Molly McGuire
Assistant Planner
Community Planning & Development
City of Mercer Island
9611 SE 36th Street
Mercer Island, WA 98040
Molly.McGuire@mercerisland.gov

Comment Letter for Proposed Redevelopment of 6950 SE Maker Street, Permit 2207-019

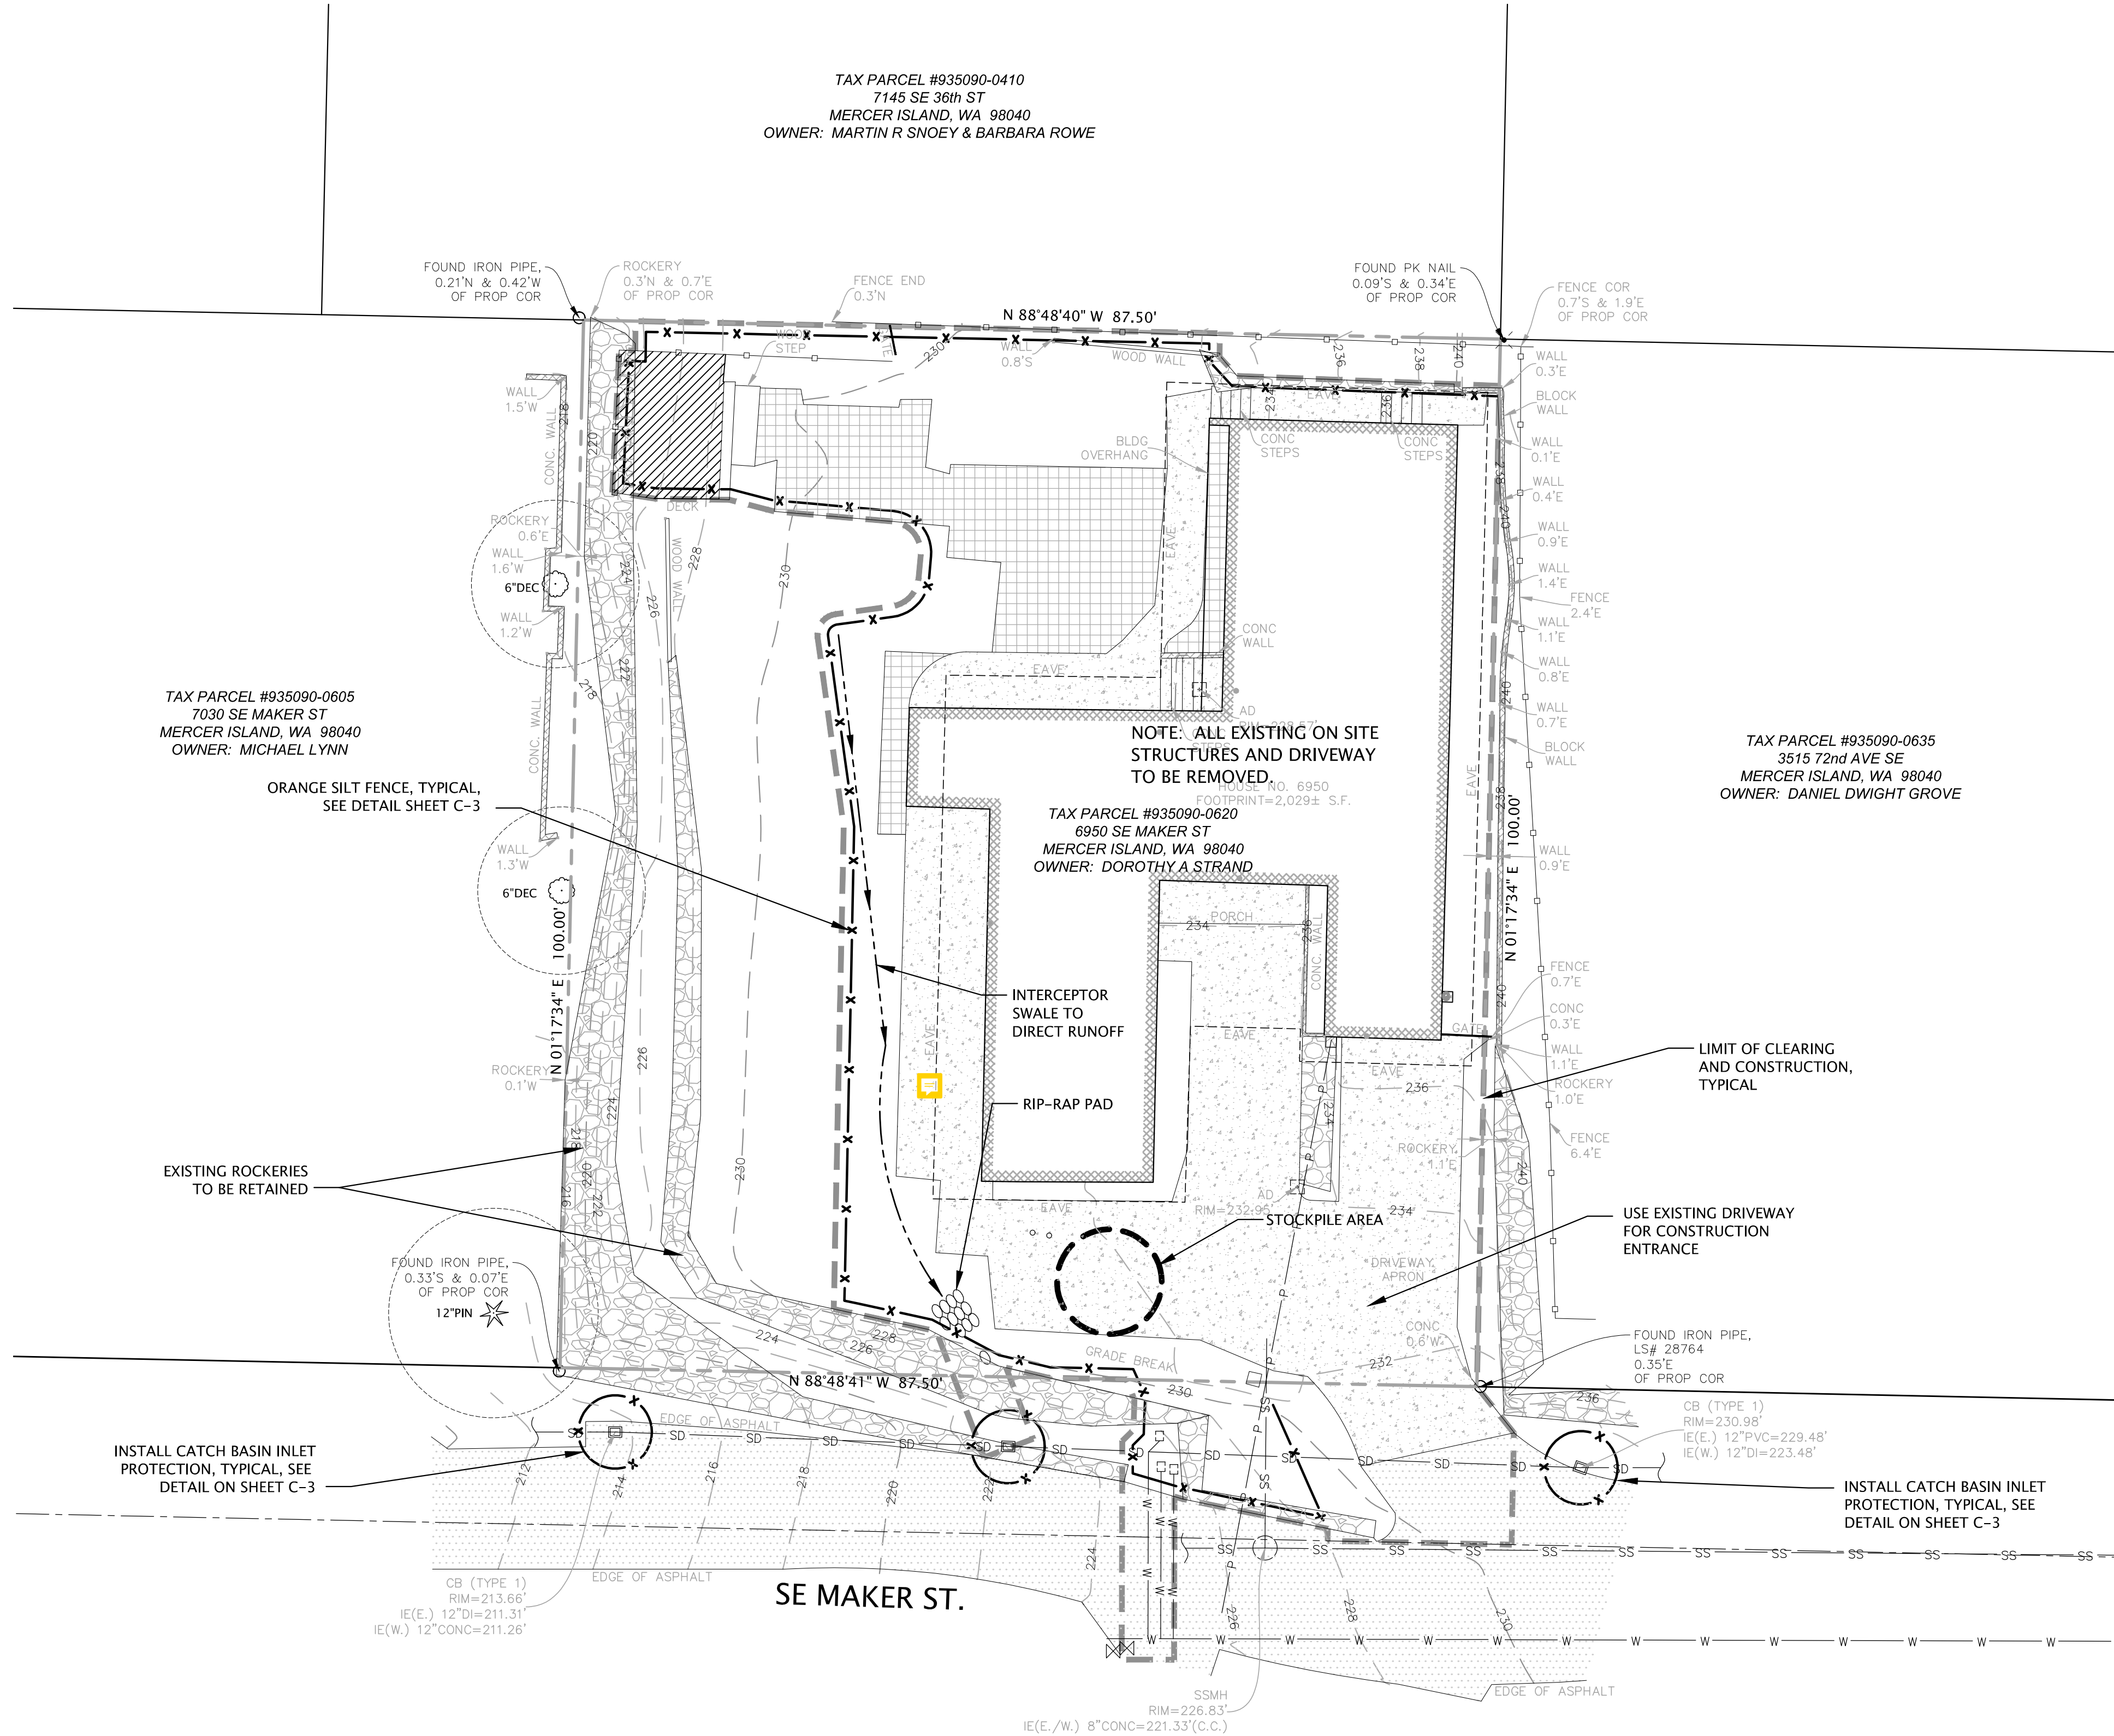
As an initial matter, the applicant's plans are all premised on faulty computation of the Existing Grade. The property is built atop an artificial grade created by "human-induced action" which "impact[ed] the existing condition of the area" and thus constitutes "Alteration" as defined in [MICC 19.16](#).¹ Using the current condition of 6950 erroneously provides a much higher elevation than its code-defined Existing Grade.

Fig. 1 drives this point home: it shows a photo of the current house at 6950 Maker, relative to the SE Maker Street roadway, with elevations indicated. The road sits at 223' at this point (as shown), while the current house is at 231.3'. The Project's plans incorrectly substitute the current grade for the code-defined Existing Grade, which results in an impermissible net gain of approximately 8'.

Consequently, the applicant incorrectly computes the Average Building Elevation² ("ABE") as 233.06.' My data offers multiple forms of evidence that the correct ABE is approximately 226.7'.
